**City of Portland, Maine - Building or Use Permit Application**  
 389 Congress Street, 04101 Tel: (207) 874-8703, Fax: (207) 874-8716

<b>Permit No:</b> 05-1747	<b>Issue Date:</b>	<b>CBL:</b> 091 H008001
------------------------------	--------------------	----------------------------

<b>Past Use:</b> Single Family	<b>Proposed Use:</b> Single Family remove existing chimney, hearth and foundation. Reframing as necessary for new footing, foundation, masonry fireplace and single flue chimney.	<b>Permit Fee:</b> \$156.00	<b>Cost of Work:</b> \$14,127.00	<b>CEO District:</b> 2
<b>Proposed Project Description:</b> remove existing chimney, hearth and foundation. Reframing as necessary for new footing, foundation, masonry fireplace and single flue chimney.		<b>FIRE DEPT:</b> <input type="checkbox"/> Approved <input type="checkbox"/> Denied	<b>INSPECTION:</b> Use Group: Type	
		Signature:	Signature:	
<b>PEDESTRIAN ACTIVITIES DISTRICT (P.A.D.)</b>				
Action: <input type="checkbox"/> Approved <input type="checkbox"/> Approved w/Condition <input type="checkbox"/> Denied				
		Signature:	Date:

12/11/05
J. HANSON / J. JOHNSON'S
JOB
909 SEASHORE
PEAKS ISLAND
SCALE - 1/2" = 1'

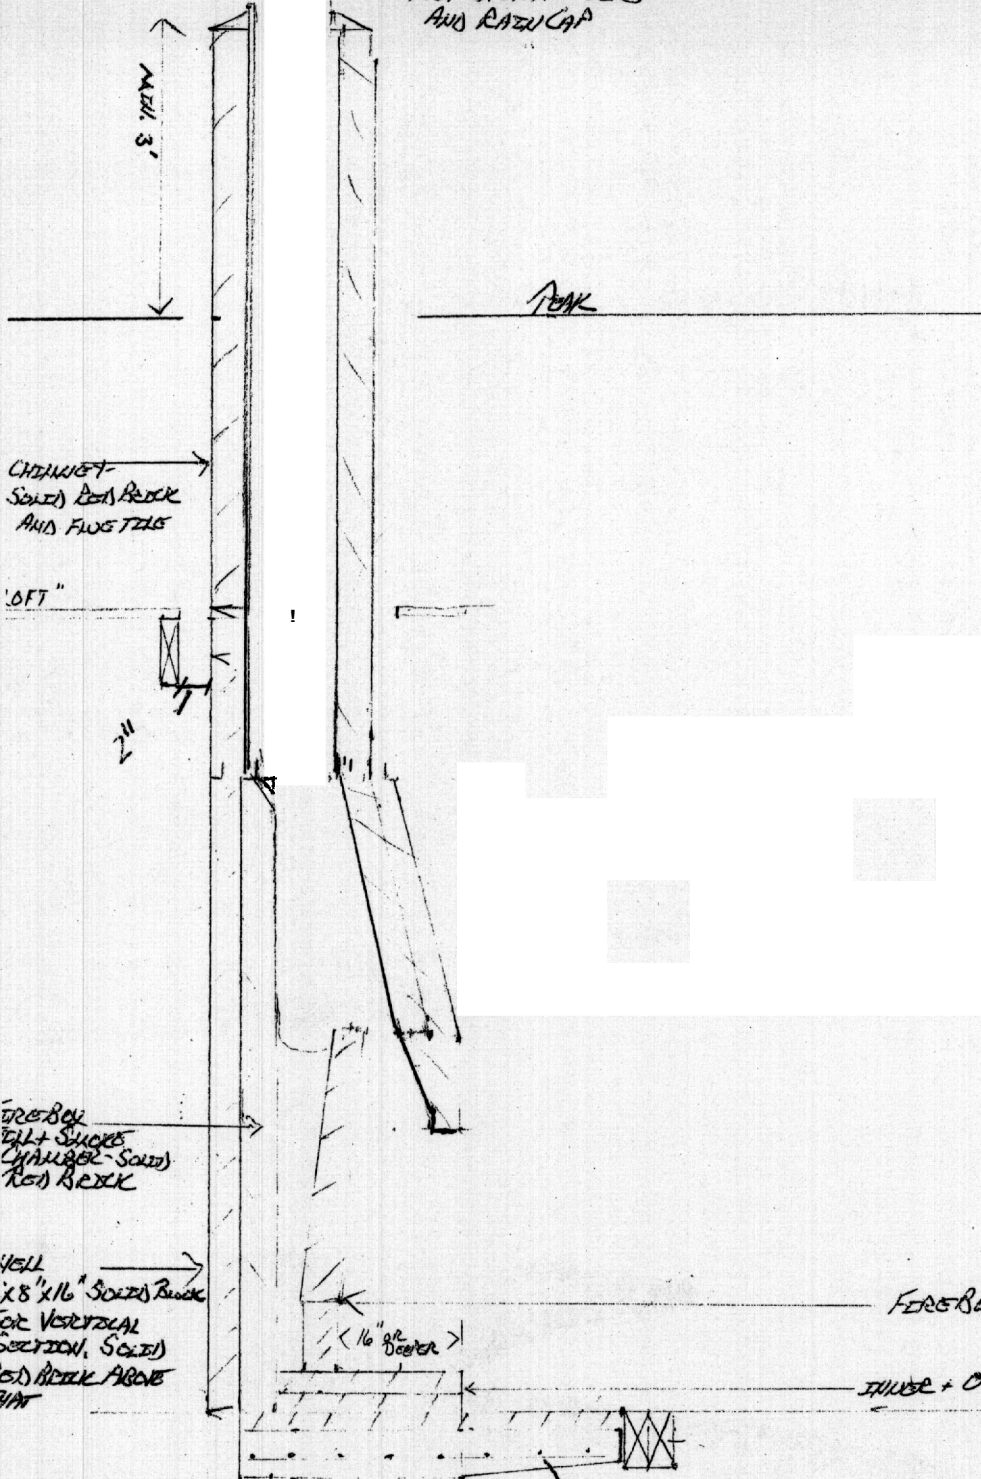
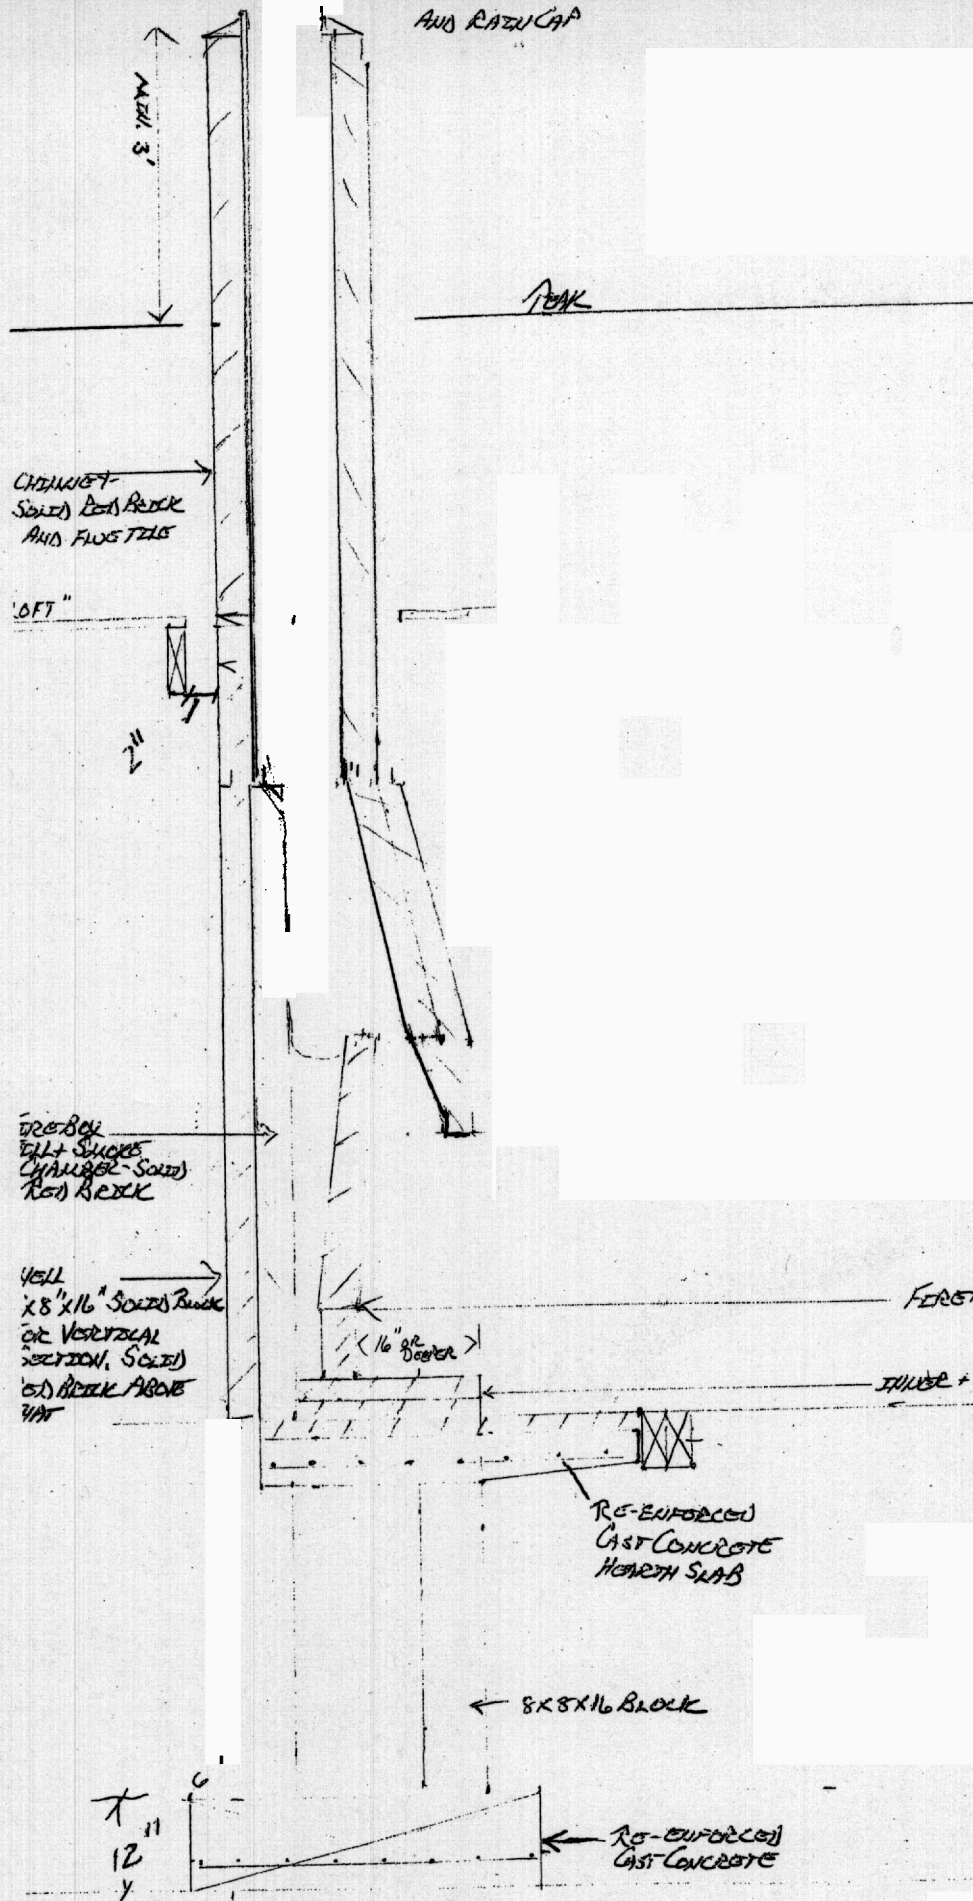
**Comments:**  
12/13/05-tmm: left message w/mason - need termination height, frost protection, footing detail, plot plan, clean out
